WELWYN HATFIELD COUNCIL – DEVELOPMENT CONTROL
DELEGATED REPORT

APPLICATION No:	S6/2010/0534/LB
------------------------	------------------------

DESCRIPTION OF PROPOSAL:

Appendix 5a: Existing rear elevation of the area work is proposed to a scale of 1:20
10 Park Street, Old Hatfield, Hertfordshire, AL9 5AX.

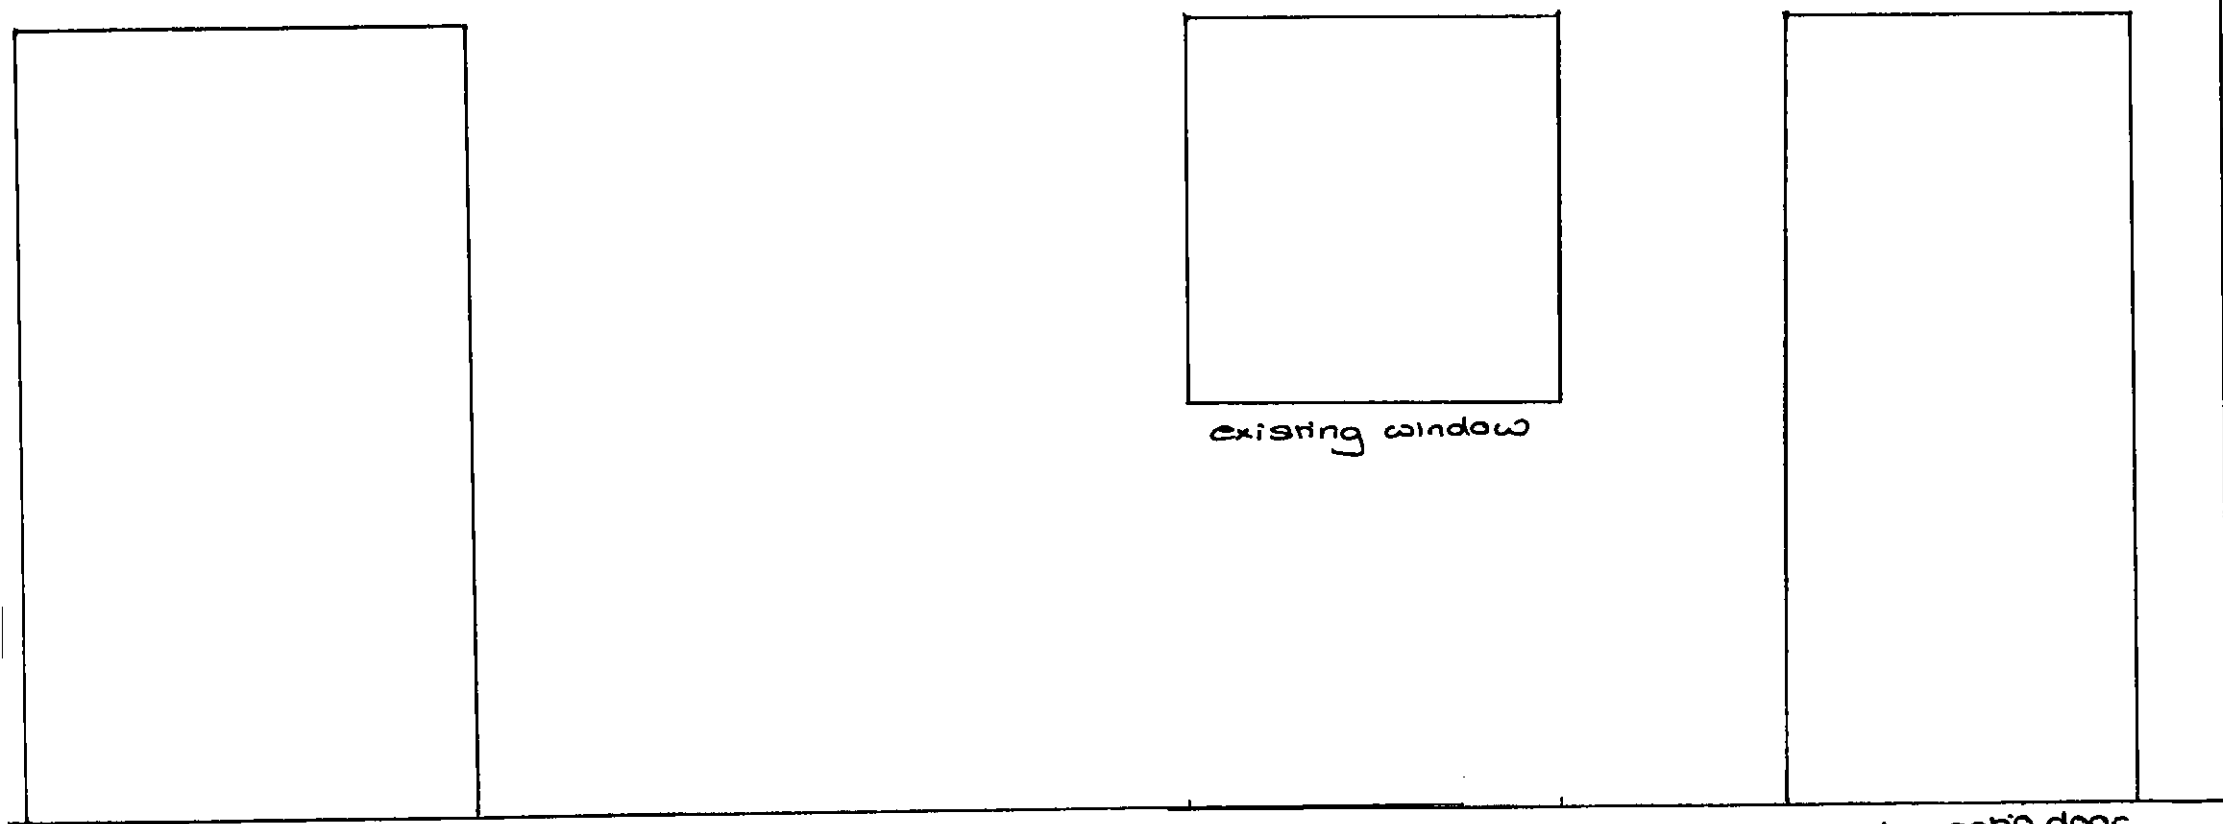
BEAMS conducted a site visit on 11th June. Concern was raised over lack of detail on the structure of the rear wall. The front elevation is still the red stock brickwork of the encasing referred to in the listed building description but the side and rear wall are now covered in a modern looking cement based render. The unknown element is whether any of the possible earlier timber frames is still forming that rear wall, For example, there could be a brace or interesting carpentry joinery in this area of wall framing the existing window.

As a result of this consultation, further detail was gathered from the applicant. The applicant responded by stating, 'the rear wall of the property is covered in a cement based render which is the same as when the building was listed. The front of the house has the exposed brickwork (also the same as when the building was listed). There is no evidence that there is an earlier timber frame under the cement casing. There is no sign at the front of the house where the brick work remains exposed.

Following this further information from the applicant, BEAMS are now satisfied that the minor alteration can be granted planning permission.
